Subject: Carlisle and I-40 Traffic Impact Study
Carlisle Blvd. south of I-40
Albuquerque, New Mexico

This letter is to inform you that the **FINAL** Traffic Impact Study (TIS) dated September 30, 2024 for the proposed Development on Carlisle Blvd south of I-40, has been reviewed.

FIGURE 1-2
SITE PLAN

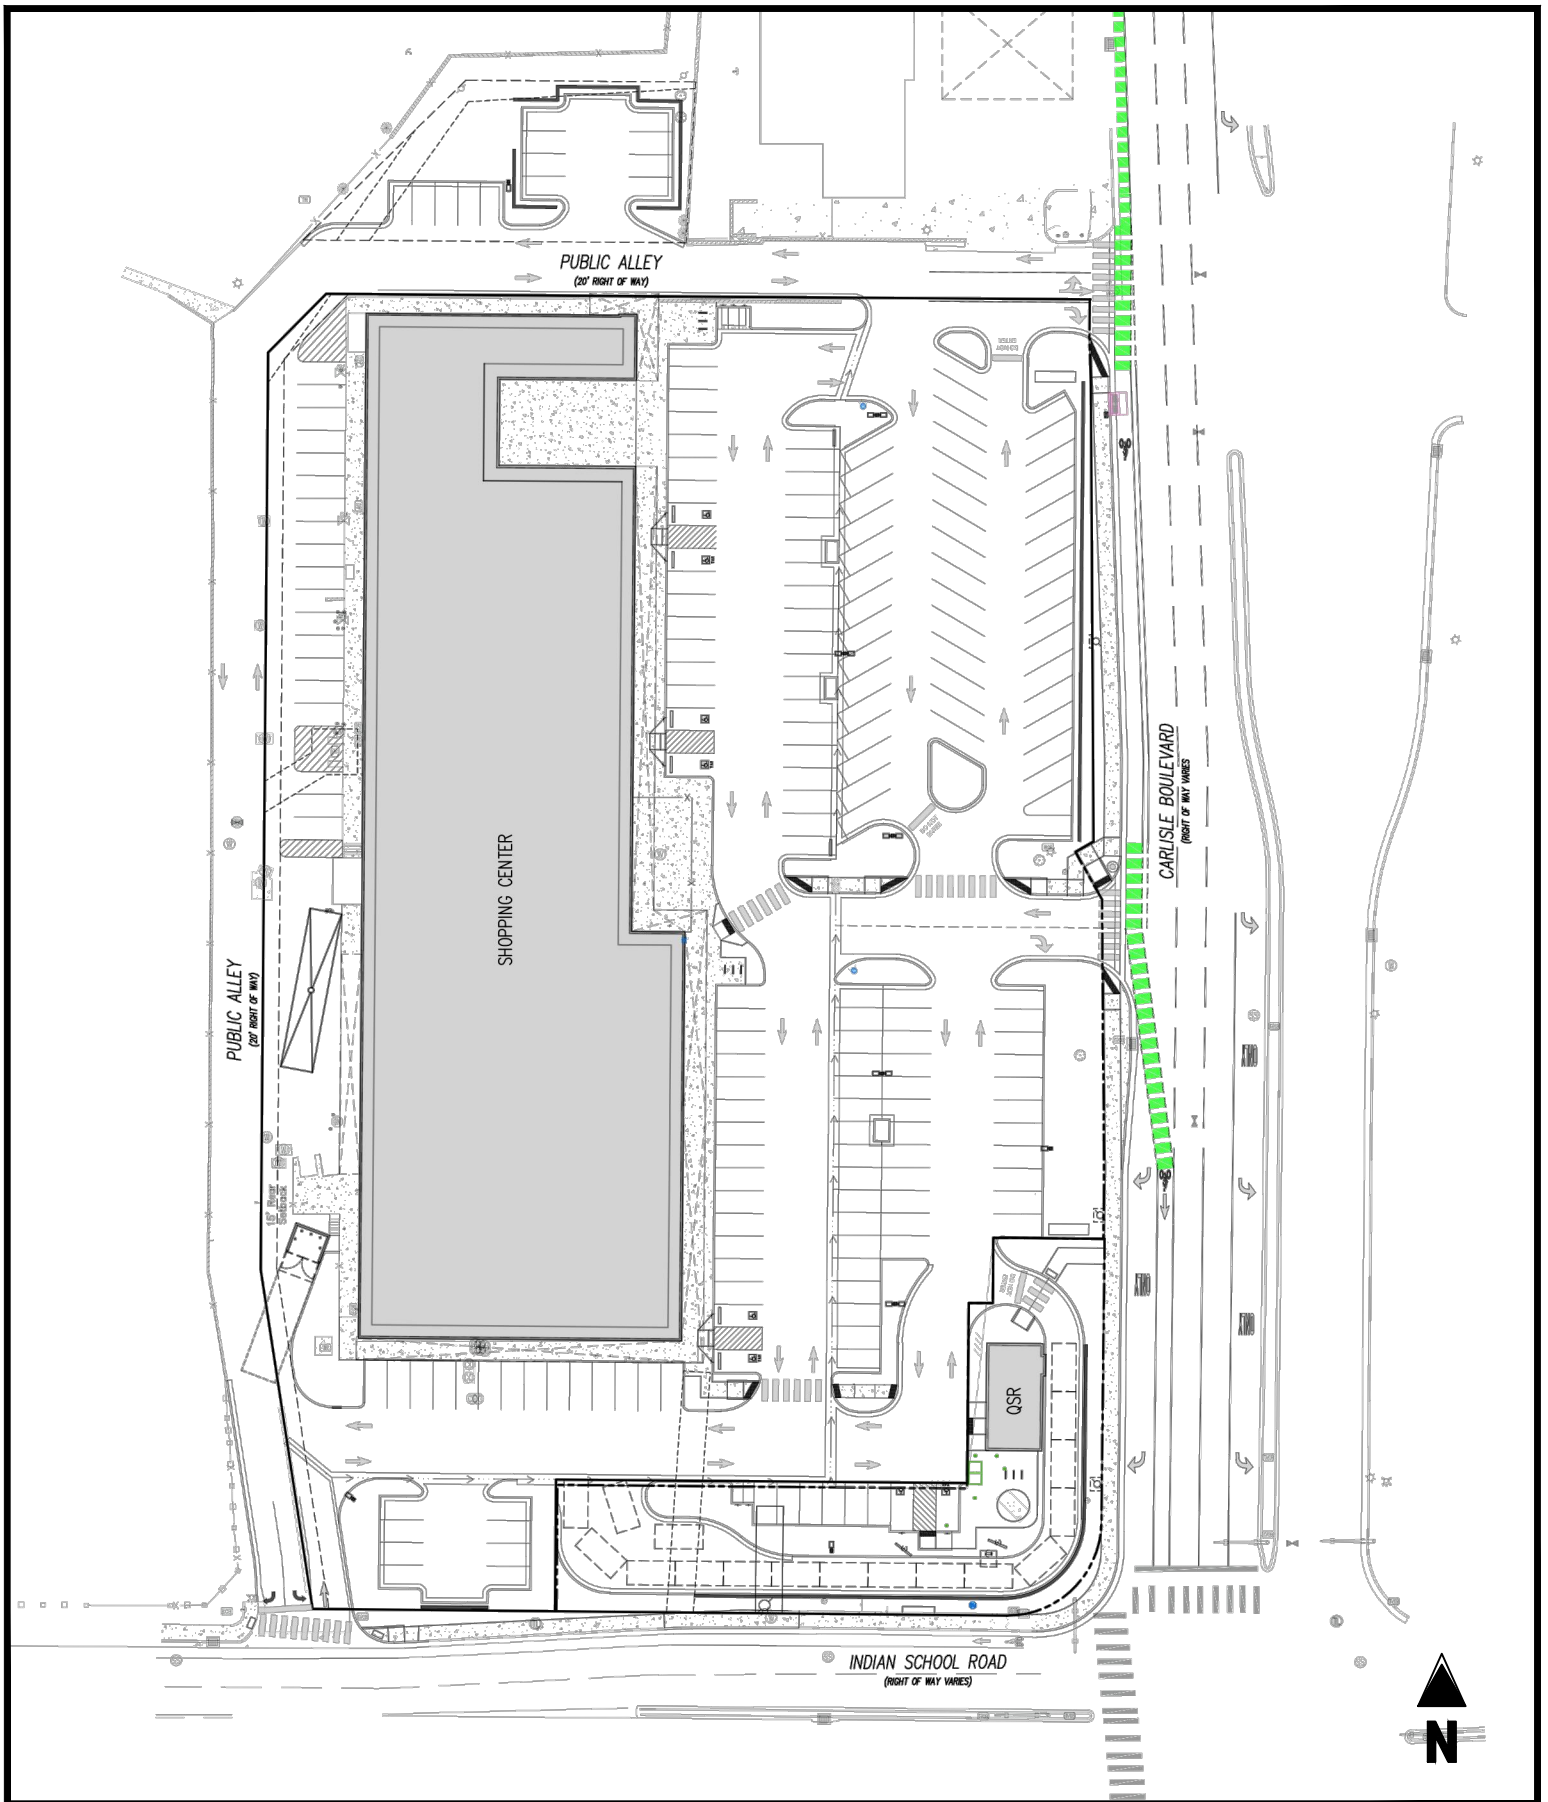
The NMDOT has no objection to the use of its existing access points on Carlisle Blvd which are located south of I-40. Please see Exhibit A for the proposed conceptual site plan and access point locations. This project is within the area of influence of the I-40 and Carlisle Blvd interchange/signalized intersection of I-40 eastbound off-ramp and Carlisle Blvd. This study has been finalized and its recommendations are attached. See Exhibit B for Conclusions and Recommendations. NMDOT gives final concurrence of this development given the conditions below are met.

1. On Carlisle Blvd provide bike lane connectivity from I-40 eastbound off-ramp to Indian School Blvd.
2. The development shall close, at minimum, one of its existing four (4) access points.
3. The development shall minimize access widths as much as possible per its appropriate design vehicle turning template.
4. The NMDOT shall provide final approval on the design for the offsite improvements. The developer shall agree to incorporate all the comments requested by the NMDOT.
